KIRKLEES METROPOLITAN COUNCIL INVESTMENT & REGENERATION SERVICE

DELEGATED DECISION TO DETERMINE APPLICATIONS FOR CONSENT, AGREEMENT OR APPROVAL REQUIRED BY CONDITION

Reference No:	2026/44/92208/W
Site Address:	Land off, Hermitage Park, Lepton, Huddersfield, HD8 0JU
Description:	Discharge of details reserved by condition 33 (refuse collection) and 41 (access gate) of previous permission 2025/90105 for variation of previous outline permission 2022/91735 (with access and layout) for the erection of 80 dwellings and associated works
Recommending Officer:	Victor Grayson

Drawing Title
**Maintenance Access/
Emergency Access Gate**

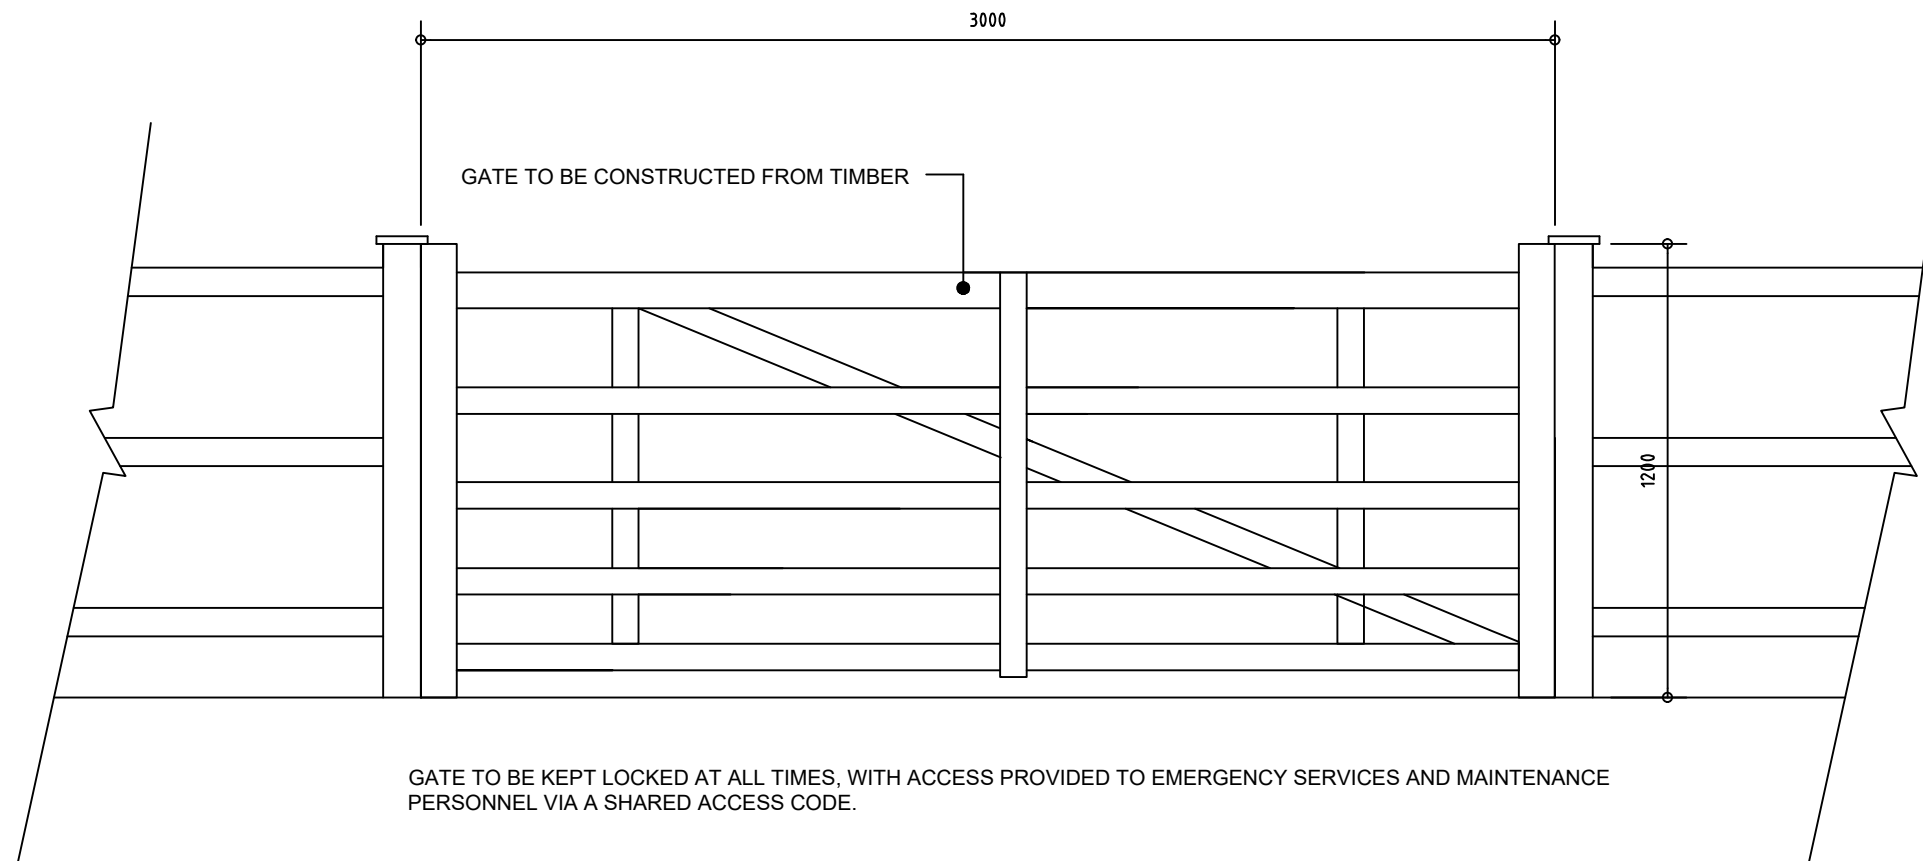
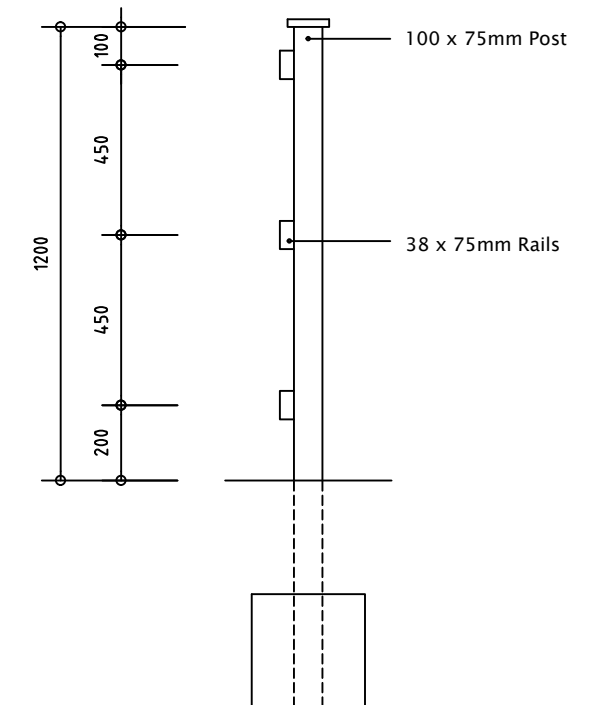
The applicant has submitted a Maintenance Access / Emergency Access Gate drawing (811176) pursuant to condition 41. This shows a timber gate (3m wide, 1.2m high), and includes an annotation stating:

Gate to be kept locked at all times, with access provided to emergency services and maintenance personnel via a shared access code.

The concern (that informed the council's decision to impose condition 41) related to the risk of the vehicular traffic of future development to the south (on the remainder of allocated site HS3, and on allocated site HS2) accessing the local highway network via Hermitage Park. Only the traffic of the 80 dwellings being developed at the application site should be able to use Hermitage Park in this way, and the hammerhead road terminus adjacent to the pumping station (and to the rear of plot 53) should not become a through-route for vehicular traffic.

The proposed timber gate is considered acceptable in visual amenity terms, and would complement the adjacent boundary treatments (1.2m post and rail fencing) currently proposed around the hammerhead under Discharge of Conditions application 2025/93549.

You have submitted a Maintenance Access / Emergency Access Gate drawing (811176) pursuant to condition 41. Details set out therein are acceptable for the purpose of condition 41, and are hereby approved. Please be reminded of the further requirements of the condition, which state:
